From: Gregg, Robert <Robert.Gregg@lancashire.gov.uk>
Sent: 06 August 2018 15:39
To: Rebecca Bowers
Cc: LHS Customer Service; planning
Subject: APP. 3/2018/0534 - 12 Westminster Close, Simonstone

PROPOSED GROUND FLOOR

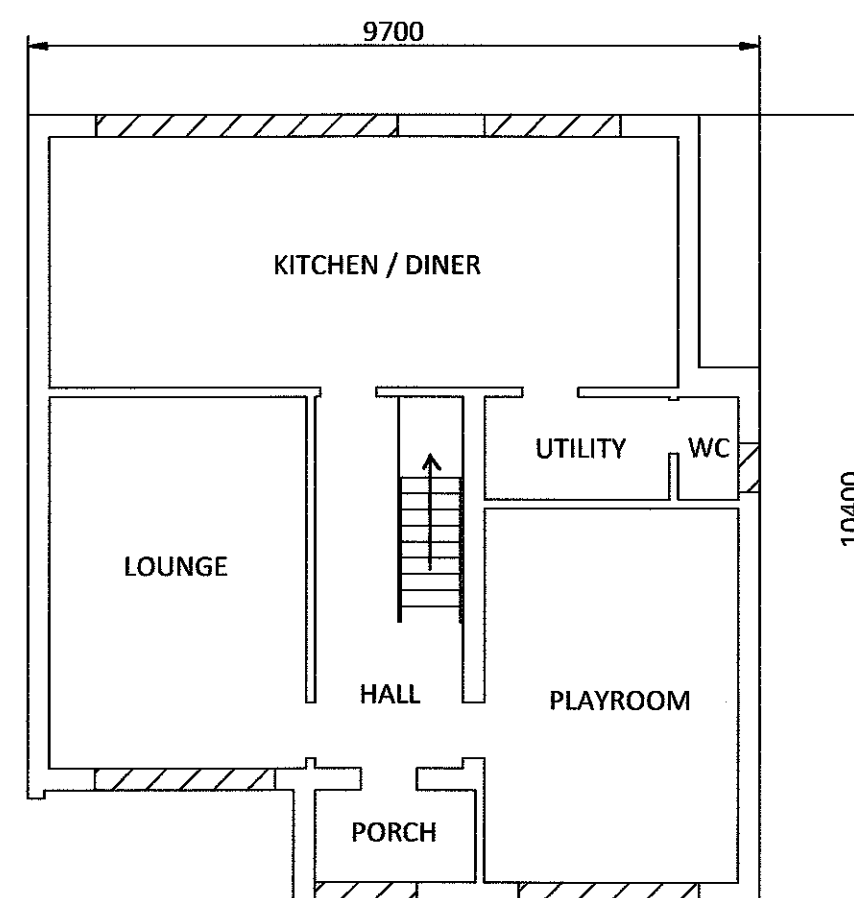
The proposal for the erection of a two storey side extension along with a porch to the front and bi-folding doors to the rear indicates from the layout that the dwelling will increase in the number of bedrooms from 3 to 4 and as a provision 3 parking spaces would be sufficient. However, As the dwelling is situated on a slight narrow bend near to a turning head and the existing drive way can only accommodate for 2 parking spaces, a further parking space will need to be established in order to comply with the provision of 3 parking spaces.

I ask that the plans be revised to indicate the proposal for 3 parking spaces.
